# Objection Submission

To: NSW Department of Planning, Housing and Infrastructure – Major Projects Assessment Team

Re: Development Application SSD-82709458 – 19–25 Balfour Street, Lindfield NSW 2070

Submitted by: Jian Jin, Owner of 1 Wallace Parade, Lindfield NSW 2070

Drawn:
**OVERSHADOWING DIAGRAMS
(PROPOSED)**

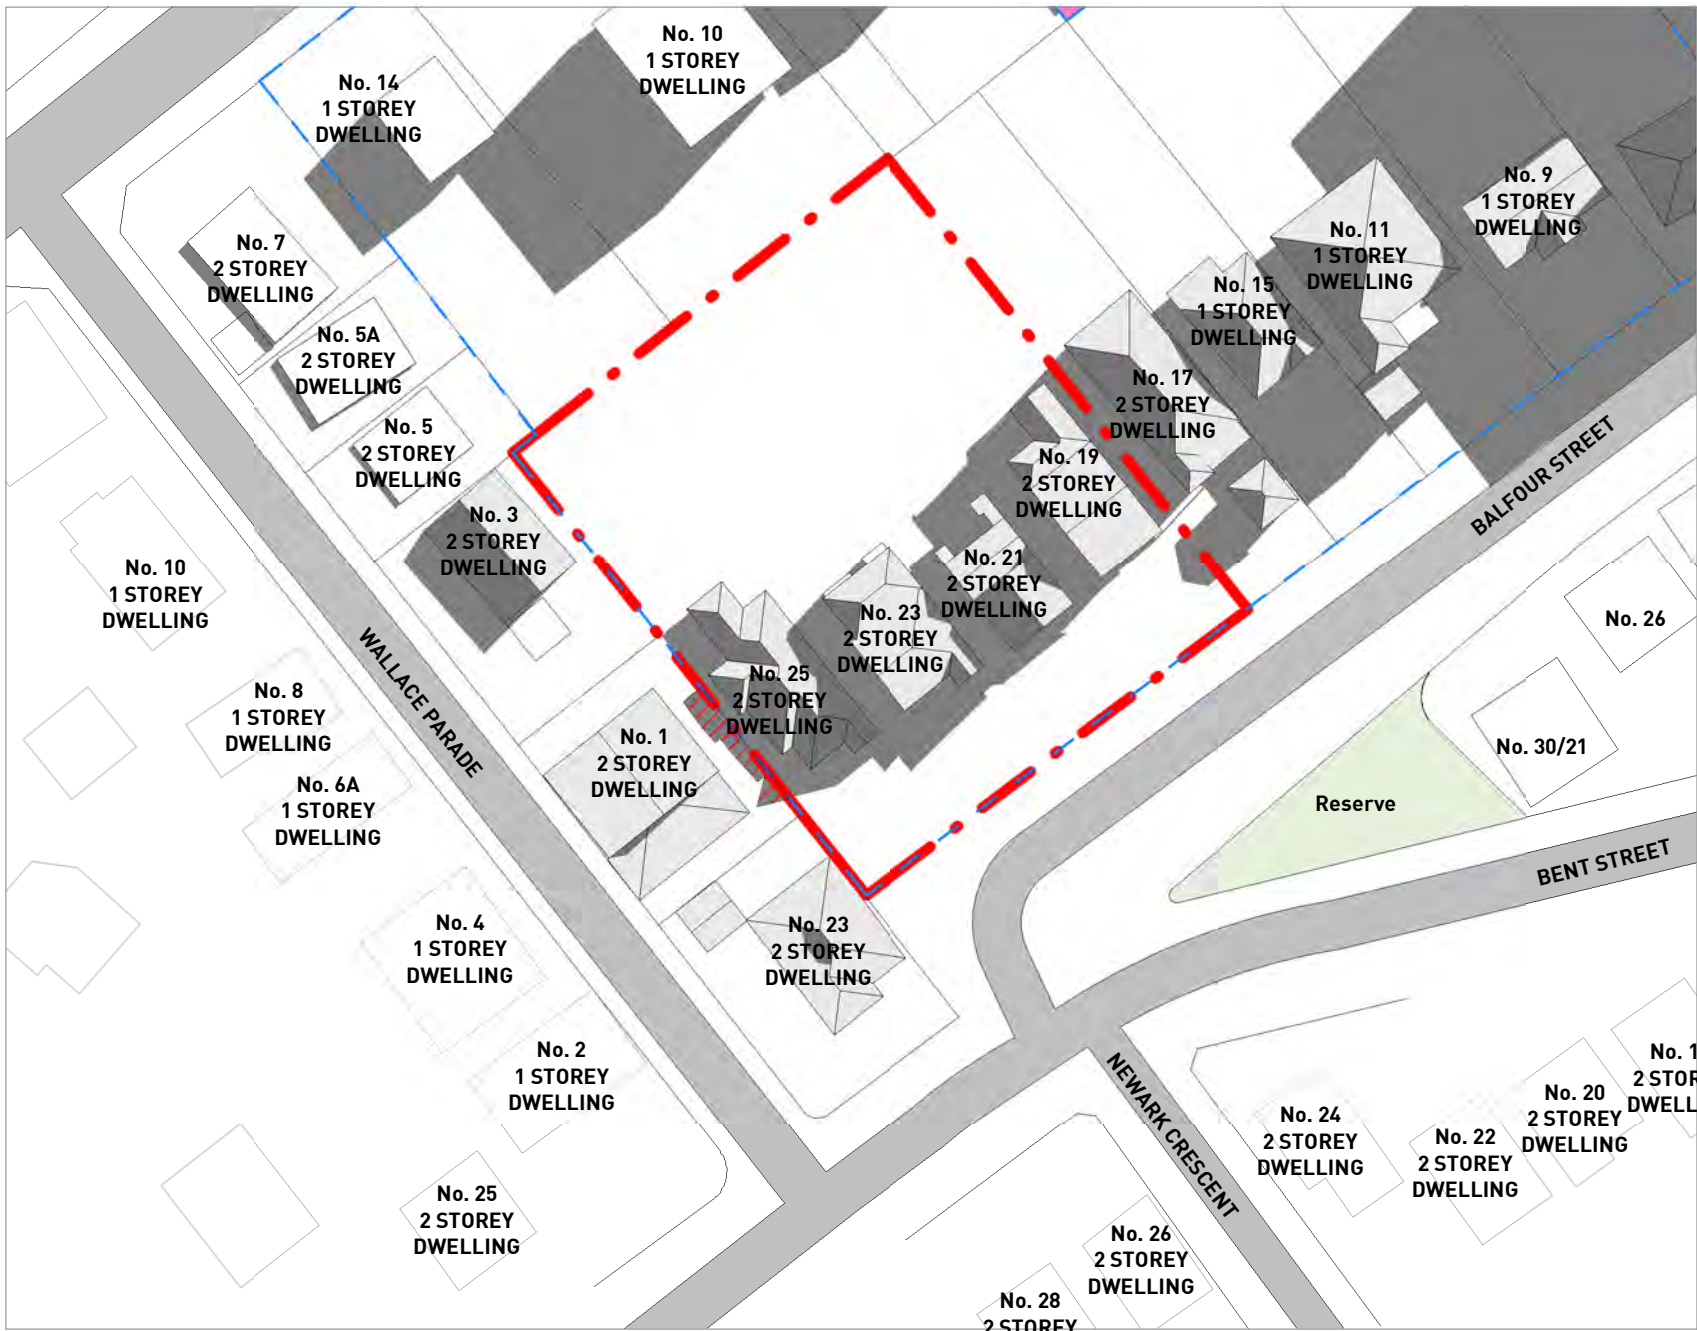
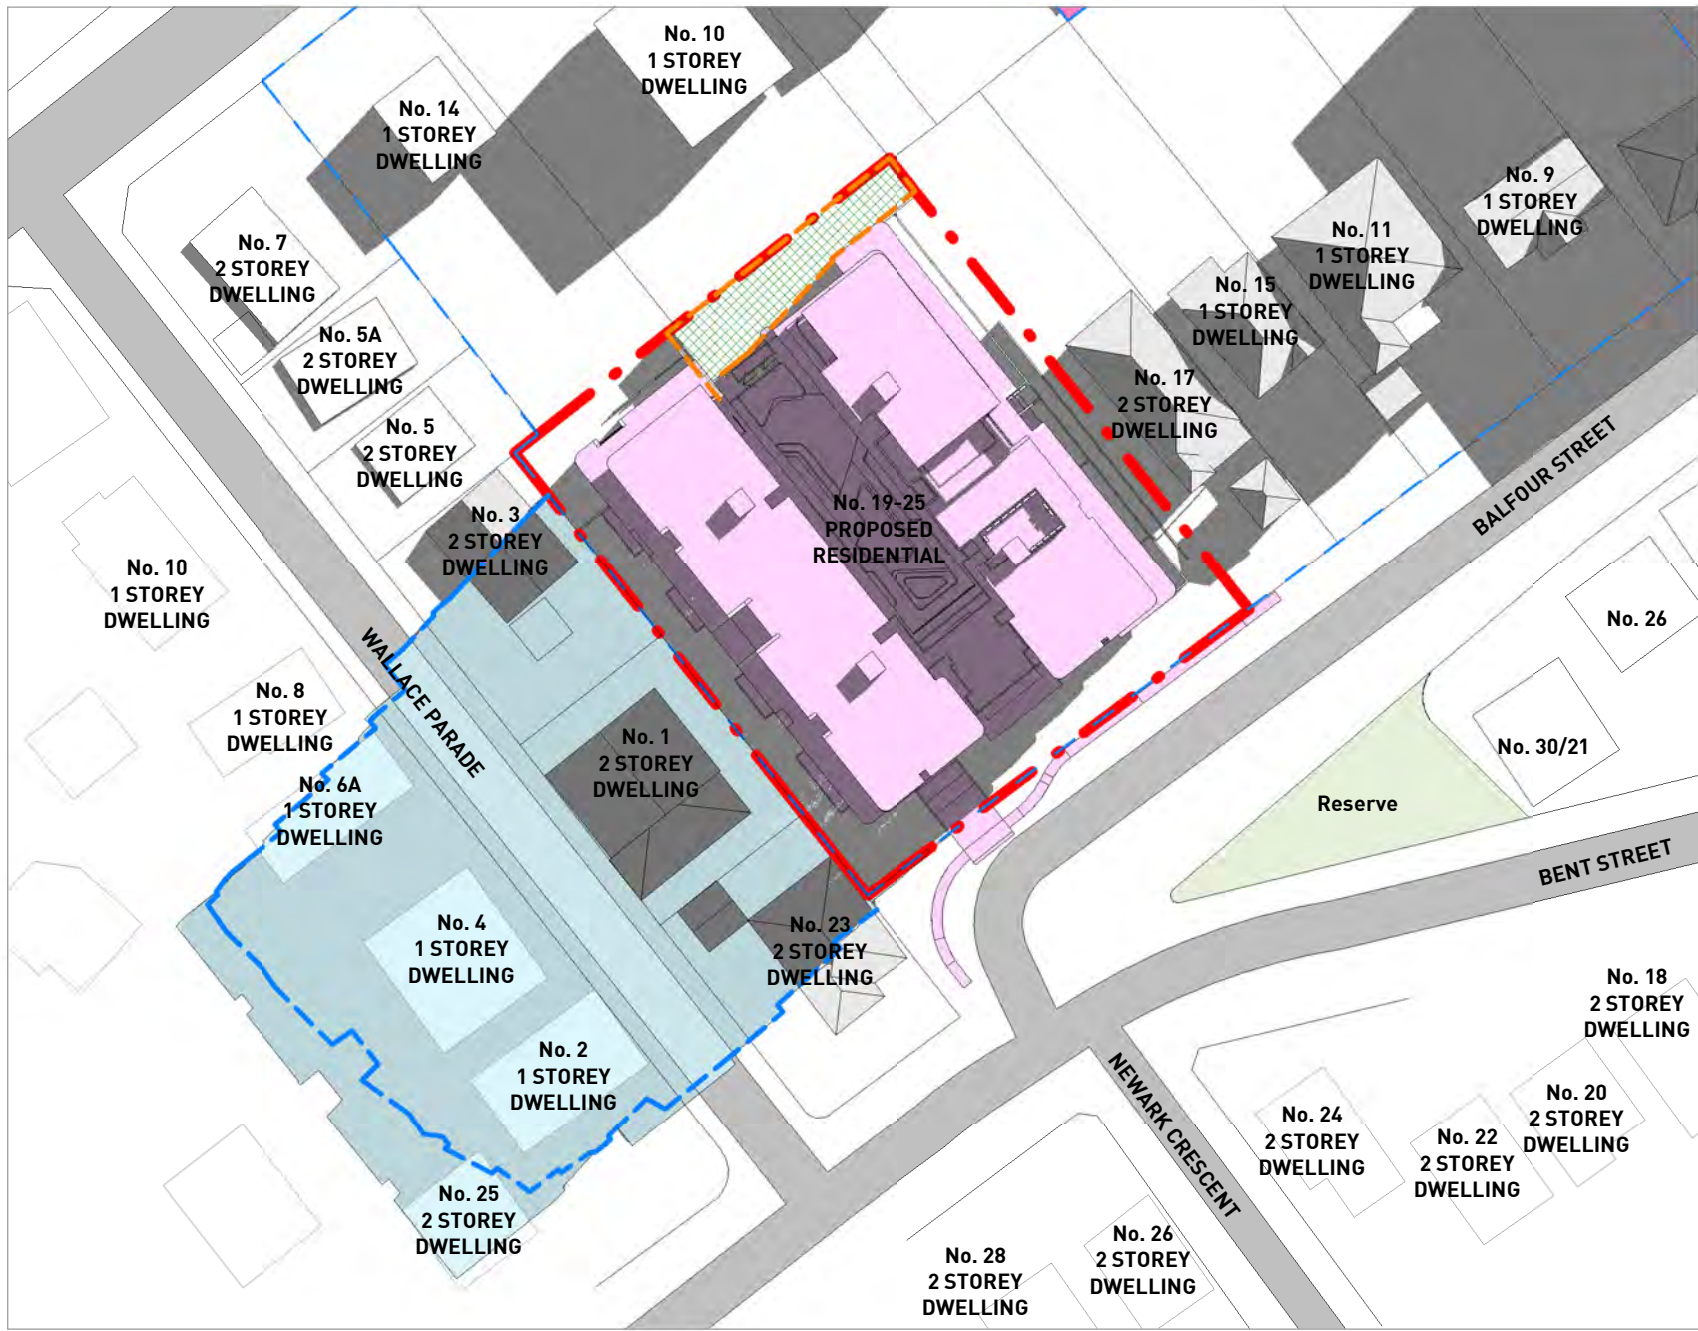
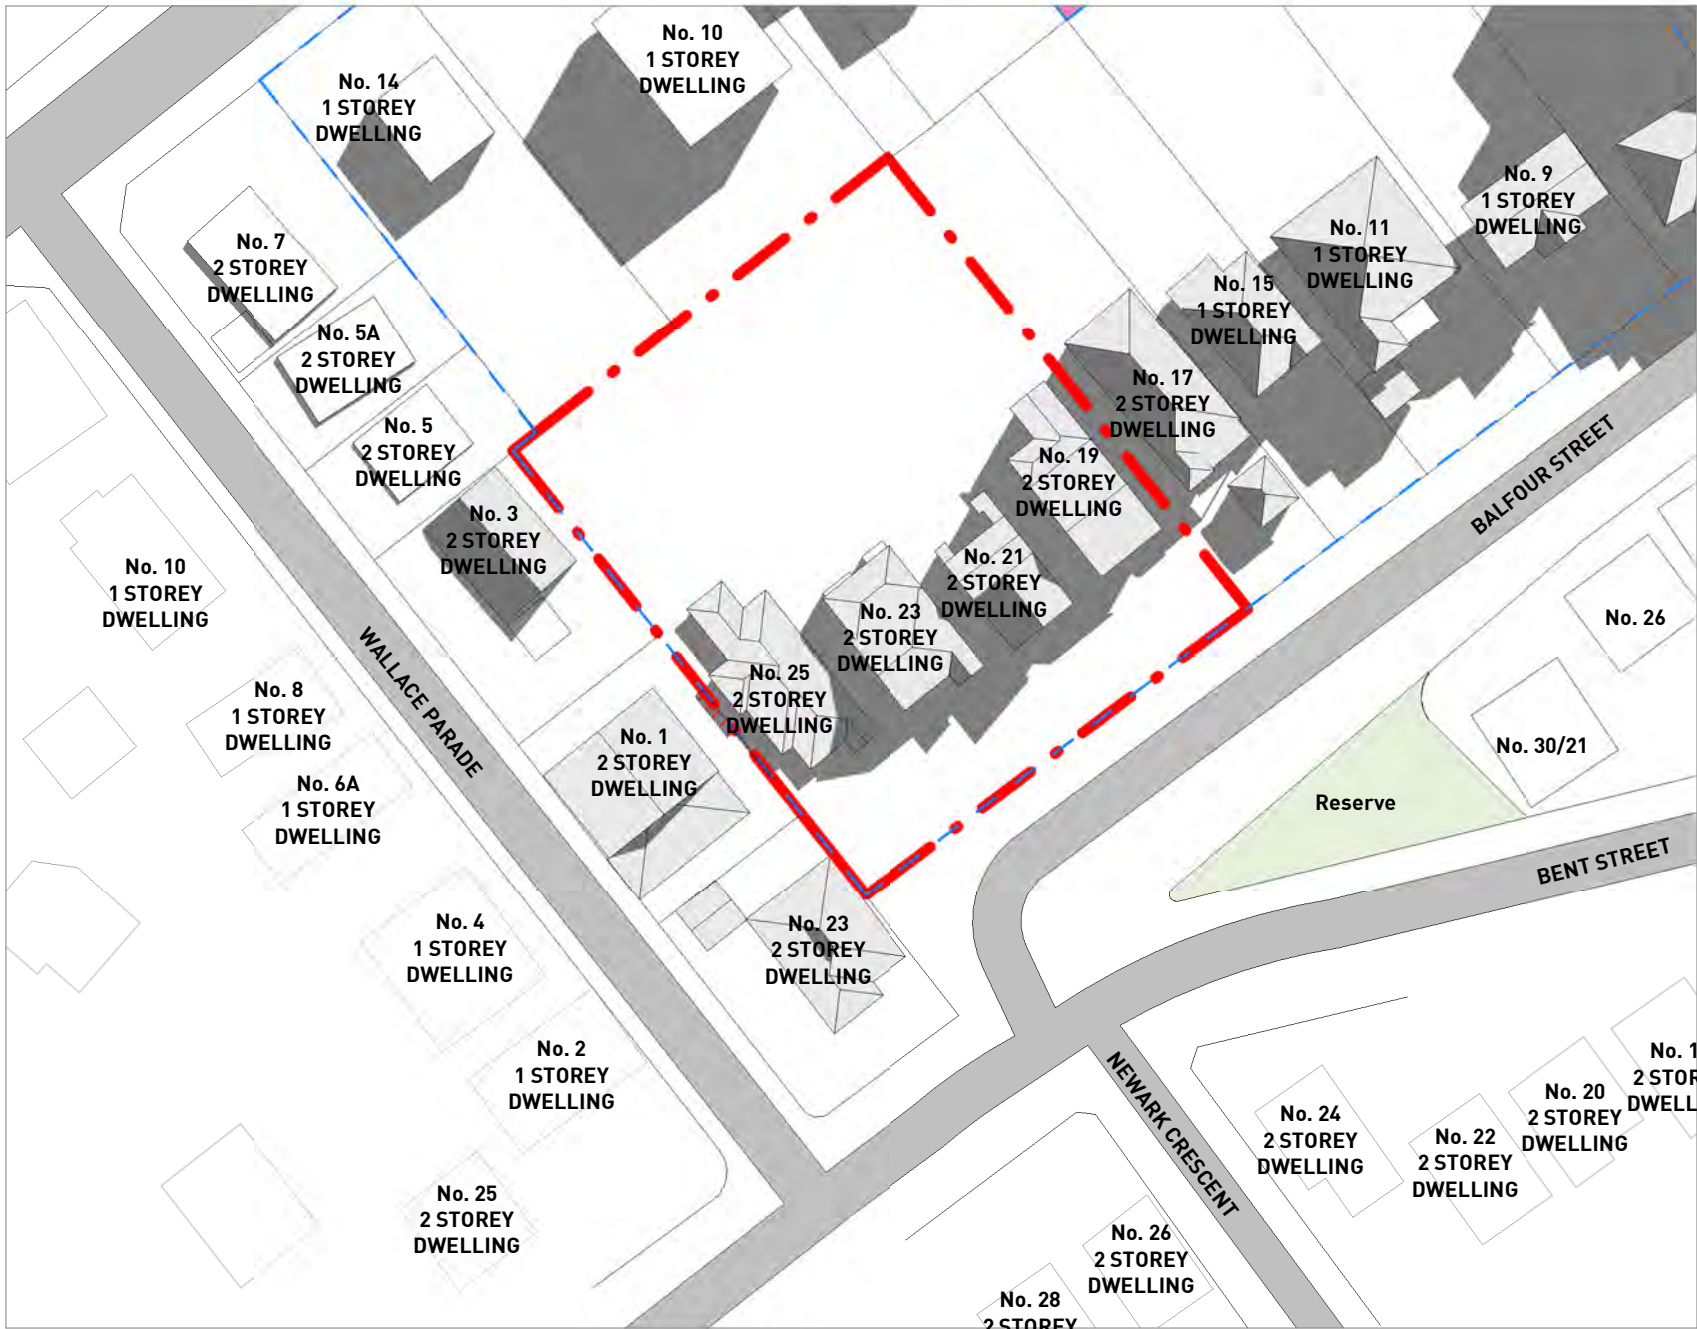
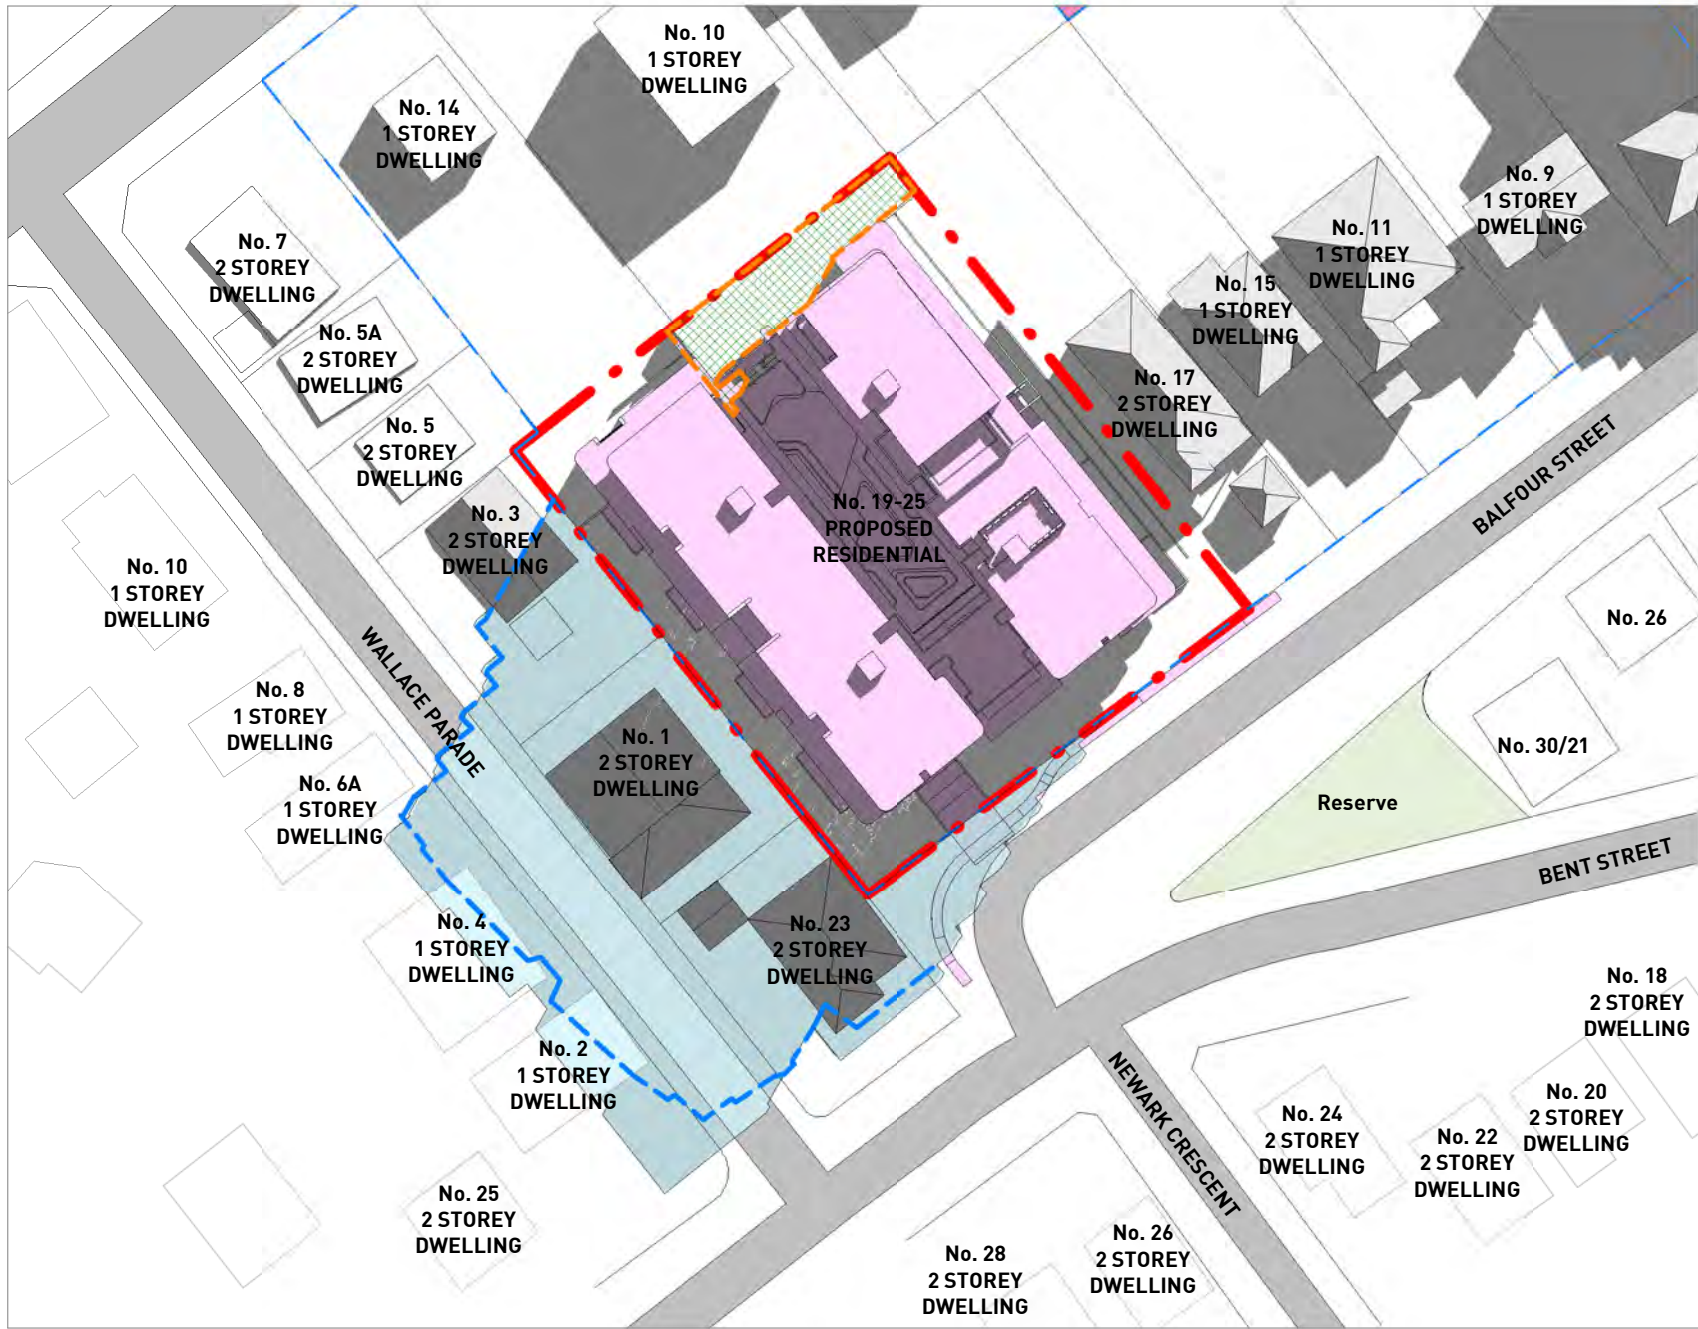
- The applicant’s shadow diagrams show that during winter solstice (22 June), surrounding low-density dwellings, including my property at 1 Wallace Parade, would not achieve the minimum three hours of direct sunlight between 9:00 am and 3:00 pm as required by the Apartment Design Guide (ADG, Objective 3B-2).
- With a proposed height of 32.7m, the building substantially exceeds the R2 low-density residential context, creating an excessive overshadowing effect.
- Long-term loss of sunlight would reduce amenity, increase winter heating demand, impair natural ventilation, and inhibit vegetation growth. Land and Environment Court precedents have recognised severe overshadowing as an unacceptable environmental impact that justifies refusal.
